Date: 13-Jul-2026
Our Ref: 2025/92161

**Application for Approval of Details Reserved by Condition
Town and Country Planning Act 1990
Planning (Listed Buildings and Conservation Areas) Act 1990**

**Discharge of details reserved by conditions 4 (finished floor levels), 5 (coal investigation), 6 (coal remediation validation), 7 (phase 1 contamination), 8 (phase 2 contamination), 11 (contamination Verification Report), 12 (CEMP), 13 (noise), 14 (Arboricultural Method Statement), 15 (CMP), 16 (highway survey), 17 (visibility), 18 (Off-site highway improvements), 19 (estate streets), 20 (waste collection), 21 (highway structures), 24 (bin storage), 25 (bicycle storage), 26 (temporary surface water), 28 (drainage management and maintenance), 29 (CEMP: Biodiversity), 30 (landscape), 34 (solar panel array), 35 (materials), 38 (crime prevention) on previous permission 2024/92281 for erection of 23 dwellings
Land adj, 17, Whitehall Road West, Birkenshaw, BD11 2LS
Application Number: 2025/92161**

Appendix 6: Garden Mitigation

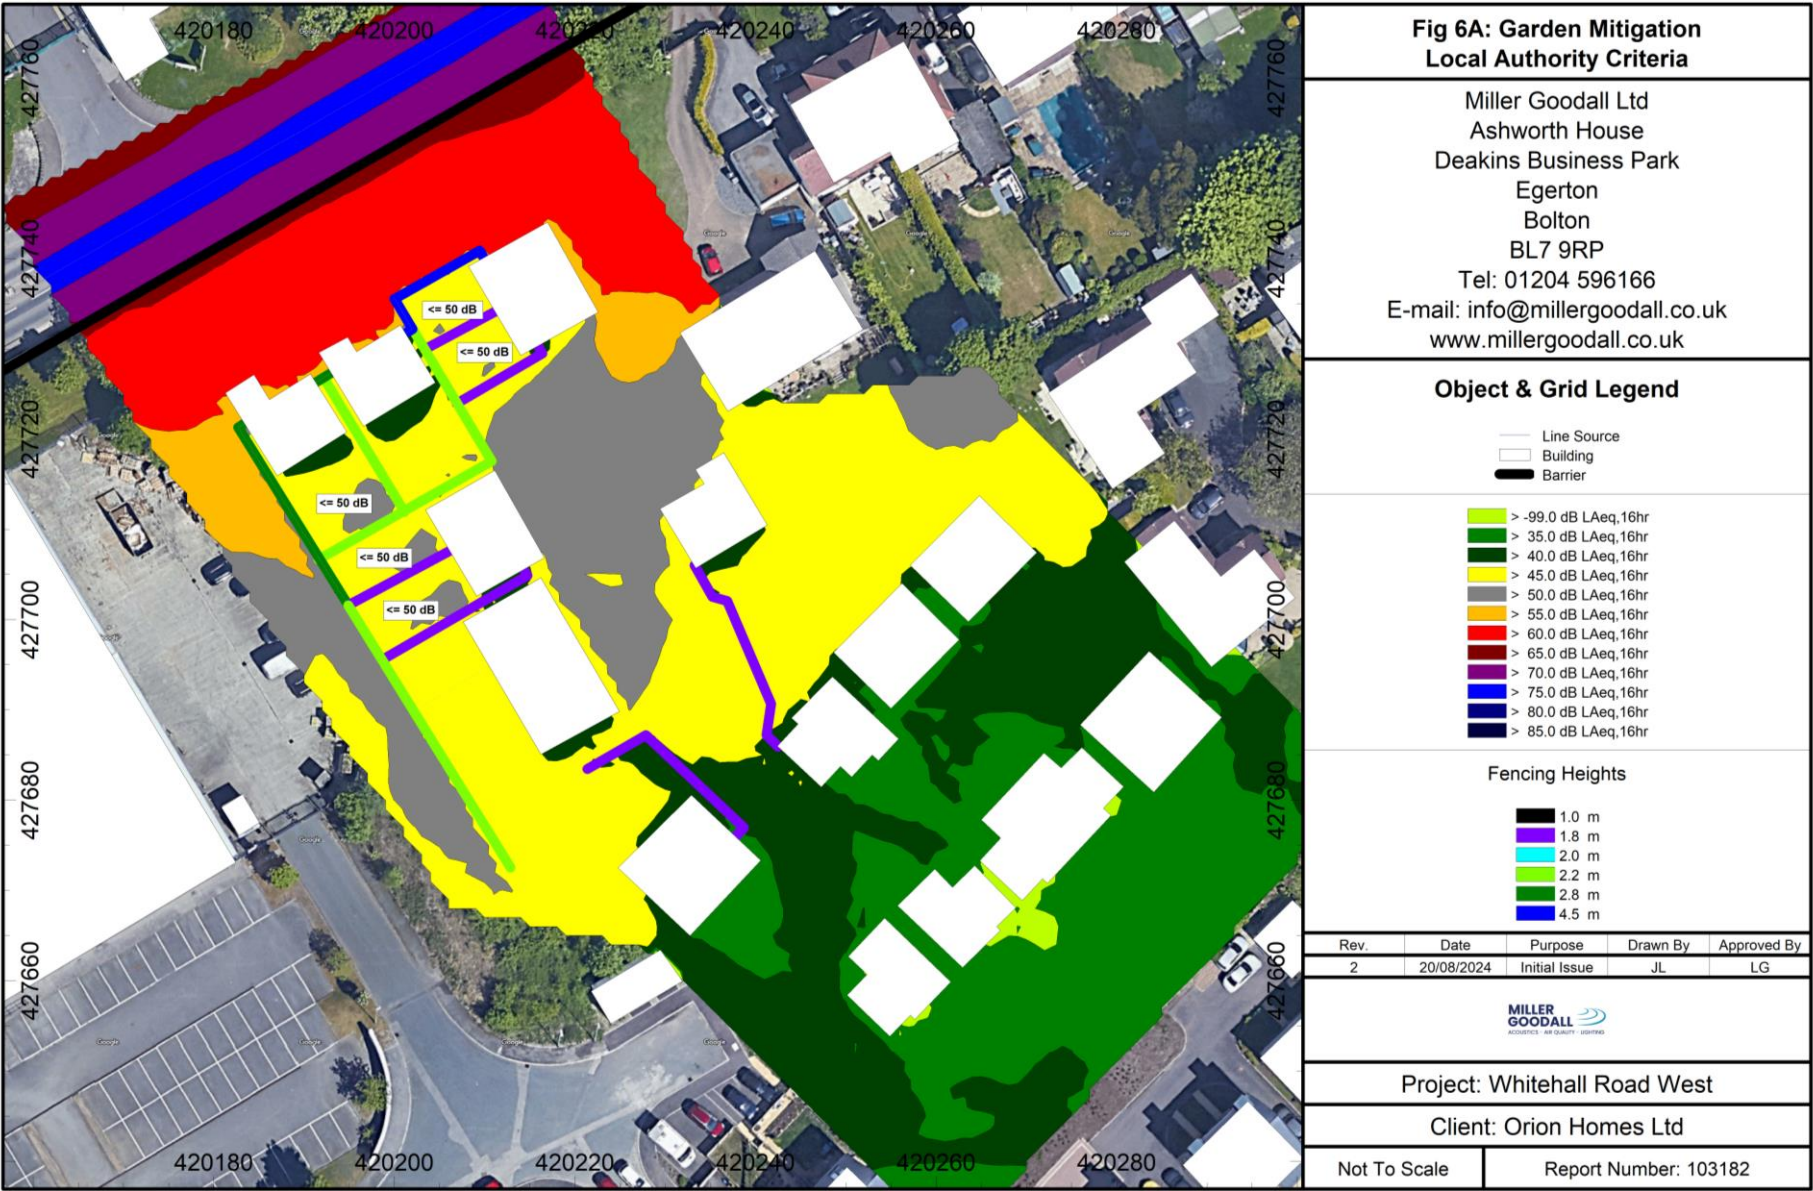
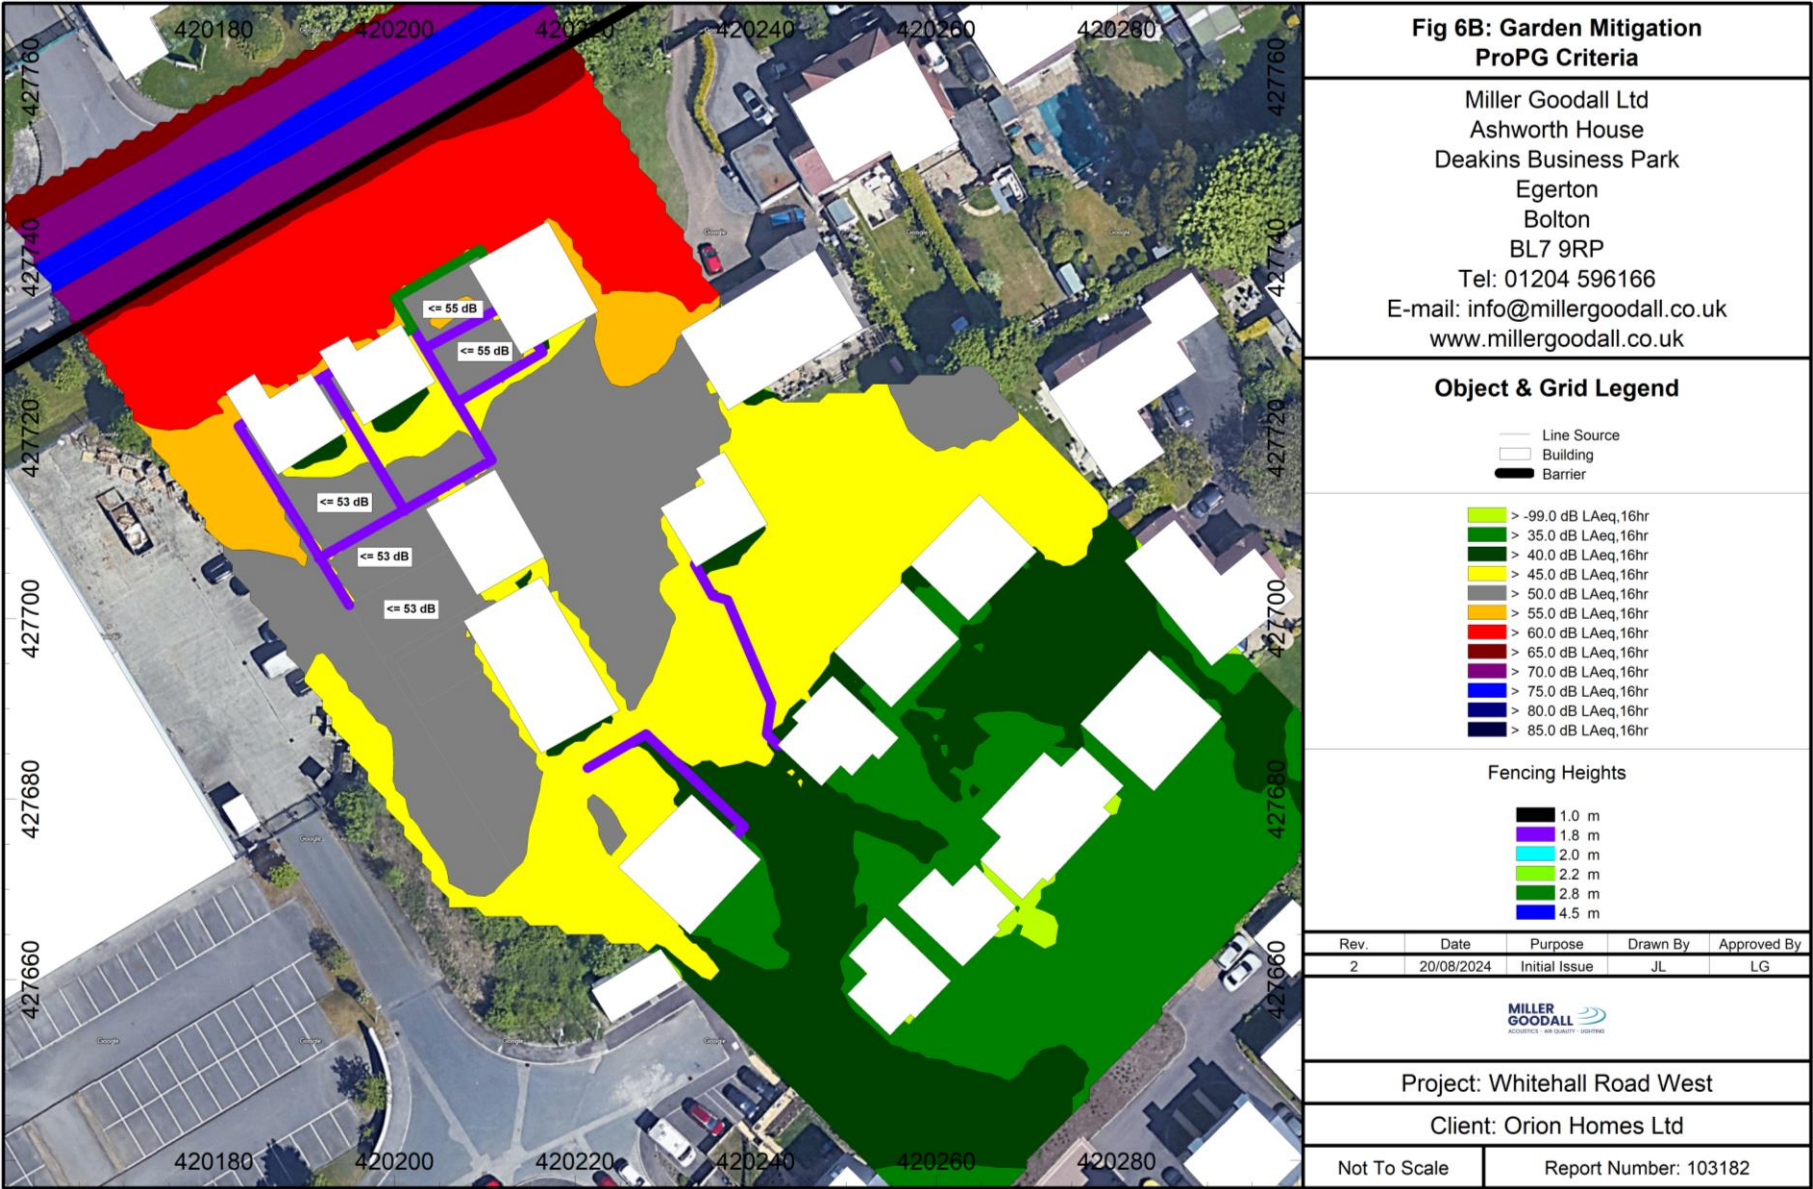
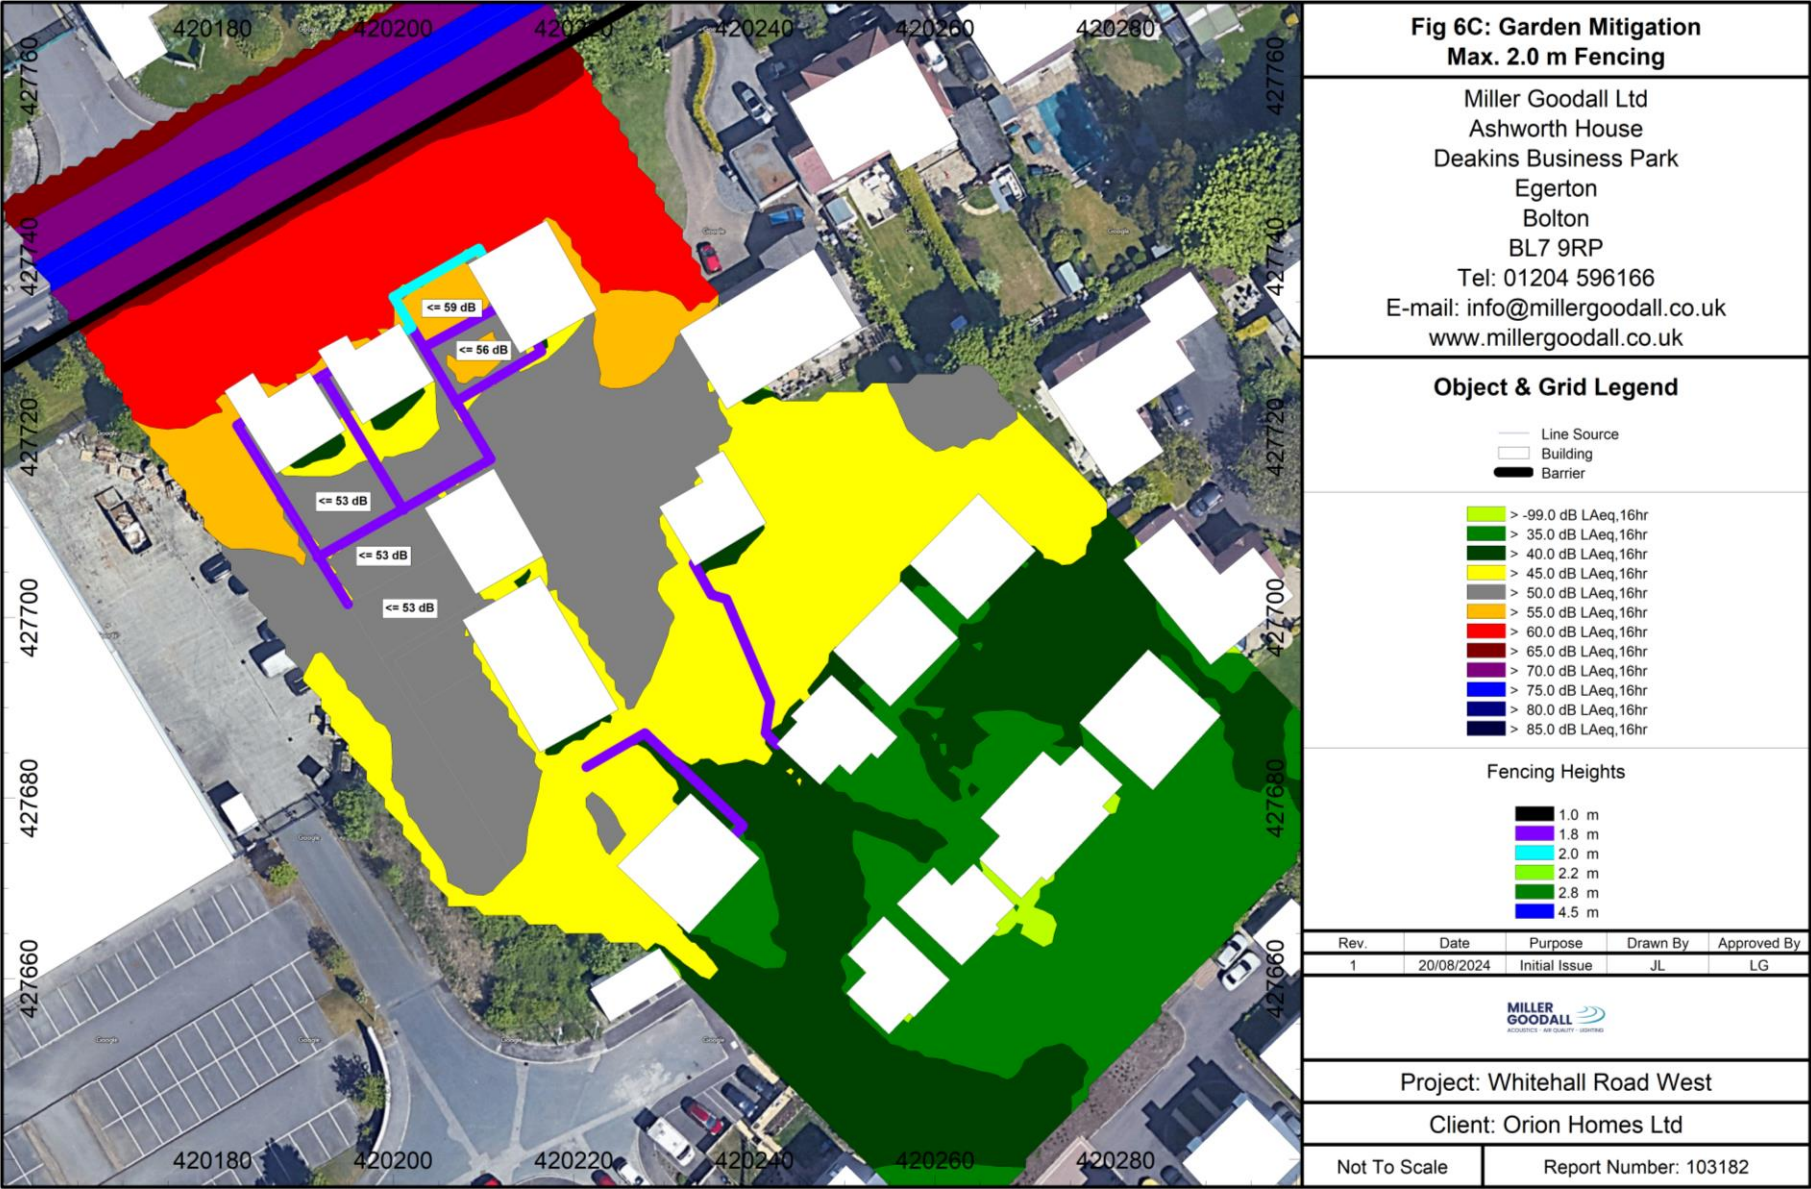
The submitted Planning Noise Assessment and Boundary Treatment Plan are considered satisfactory for the initial purposes of condition 13 and are hereby approved, on the basis that the mitigation measures for outdoor areas will be as specified in figure 6C of the Planning Noise Assessment hereby approved. For the avoidance of doubt, no acoustic fencing exceeding 2.0m is hereby approved.

The development shall not be occupied until all works specified in the approved report have been carried out in full and such works shall be thereafter retained.

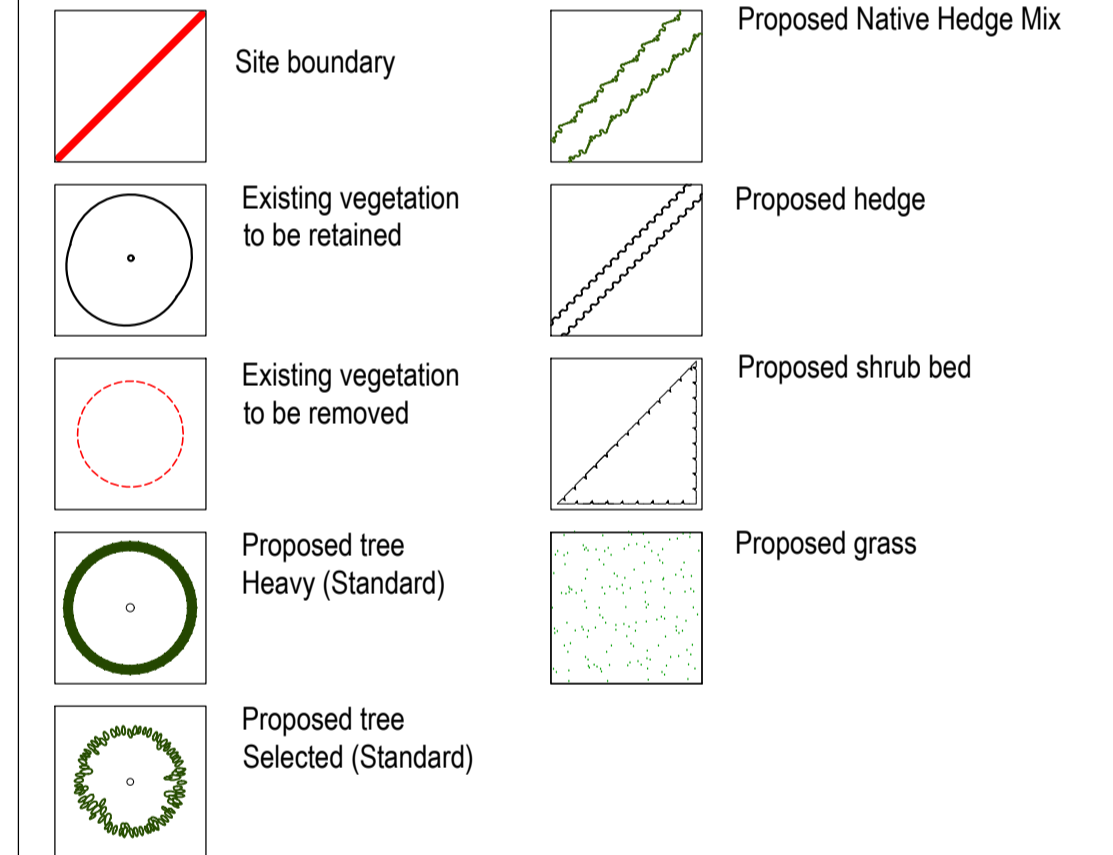
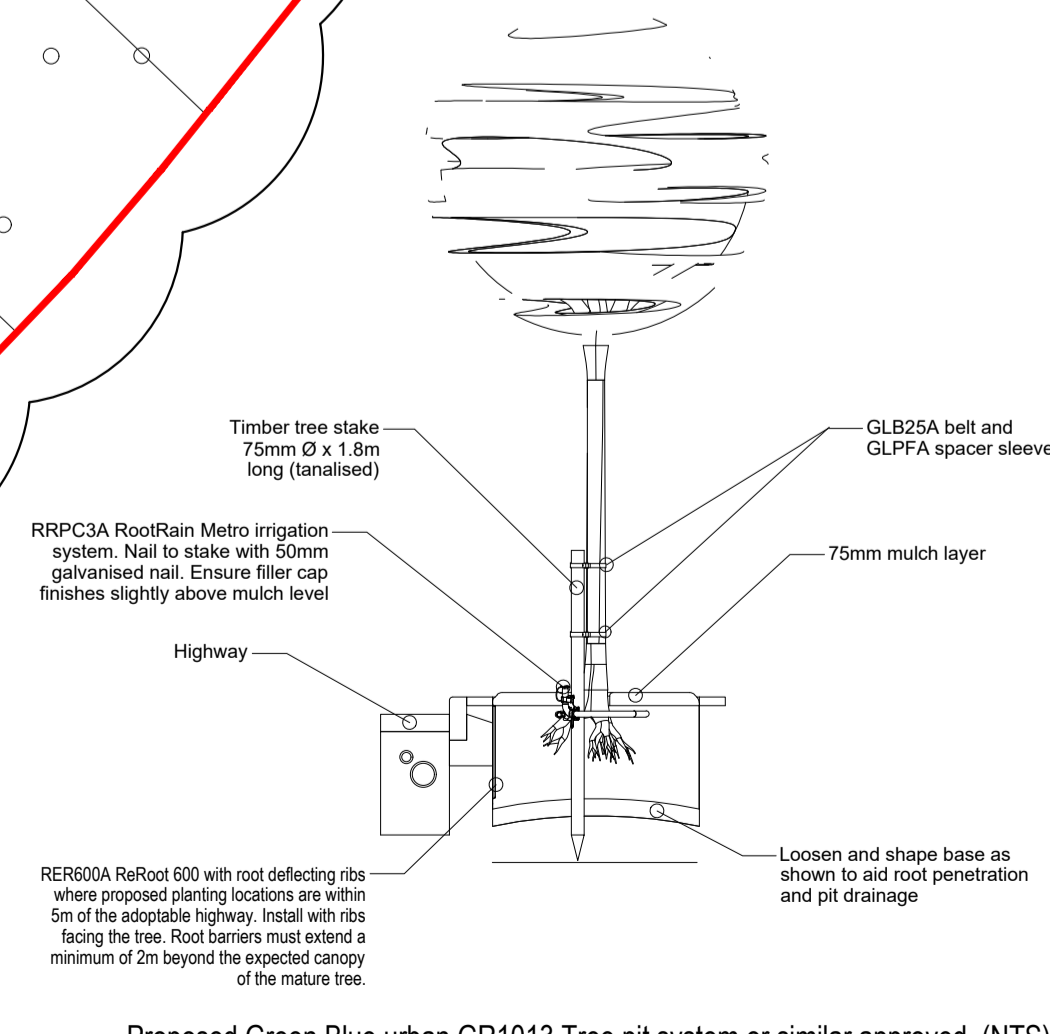
Officers would ideally have preferred to see further tree planting on the Whitehall Road West frontage. It is however acknowledged that the amount of tree planting shown on the landscaping scheme is the most that can be achieved given the constraints of the site, in particular the position of the attenuation tank and Yorkshire Water's requirements regarding the planting of trees near drainage infrastructure, based on the S104 Agreement and Drainage Layout that you have supplied. The proposed details set out within the Detailed Landscape Scheme H2 240701 1 Revision G and the Landscape Management

Specification by Stephen Heward Landscape Architect are considered acceptable for the purposes of condition 30 and are hereby approved.
